MEMORANDUM

DATE: March 29, 2005

SUBJECT: Terra Design Works (Yak. River Prop)

PARCELS: 19-16-04020-0002

**RECORD OF SURVEY**  
 A PORTION OF THE NORTHWEST 1/4 OF SECTION 4,  
 TOWNSHIP 19 NORTH, RANGE 16 EAST, W.M.,  
 KITTITAS COUNTY, WASHINGTON

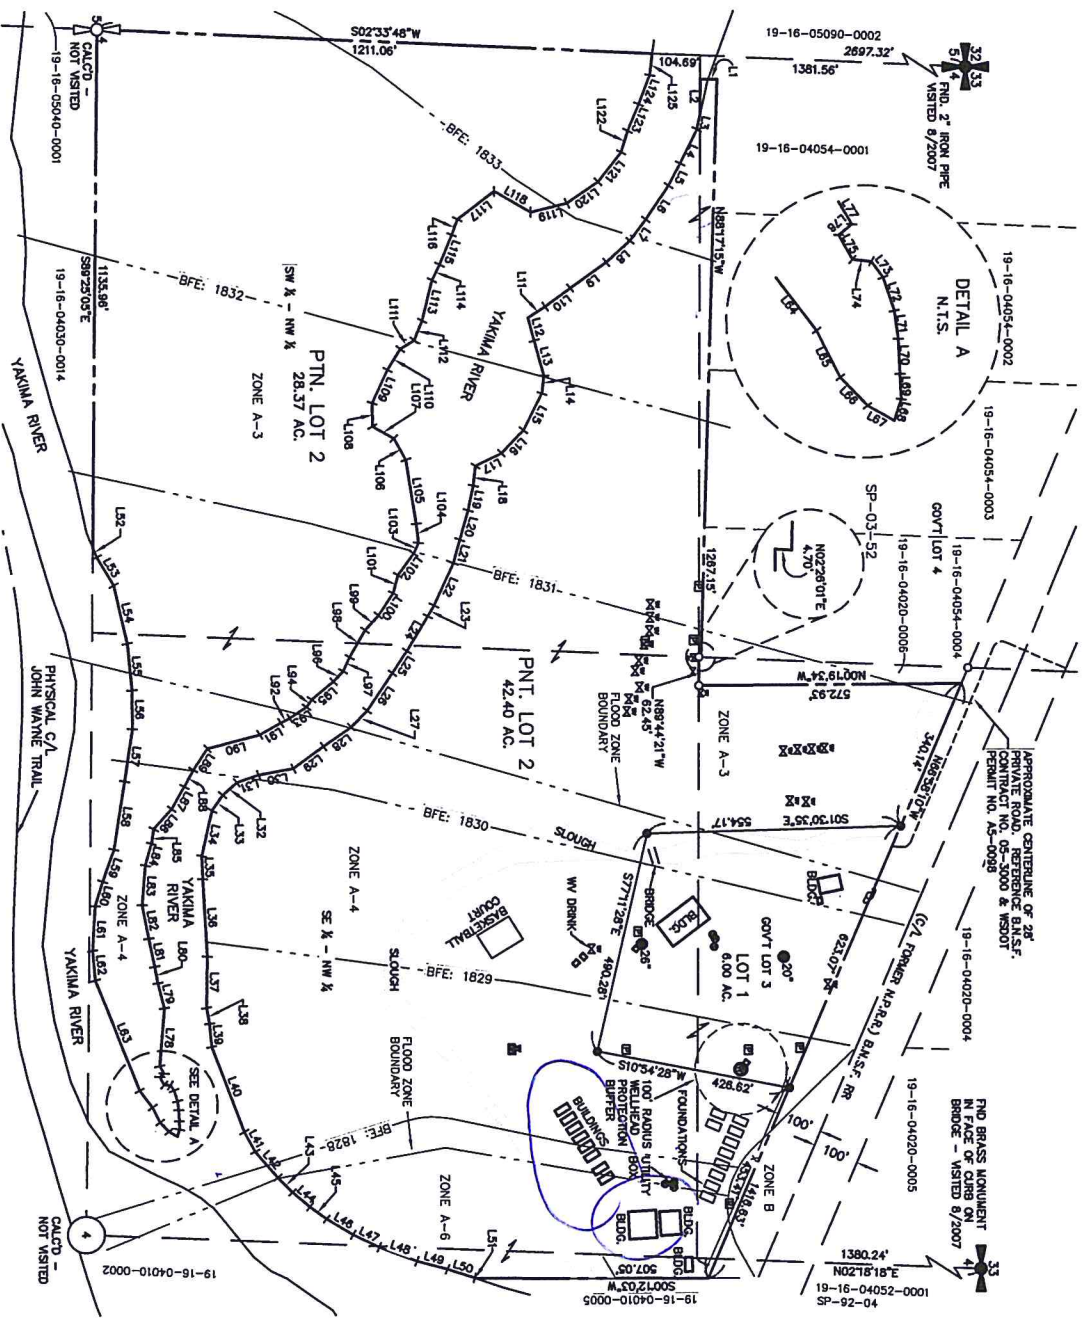
In accordance with Kittitas County Code 12.01.090B, the final recorded survey shall reflect existing County road right of way, with a minimum of 30' identified from centerline to adjoining parcels and/or affected property.
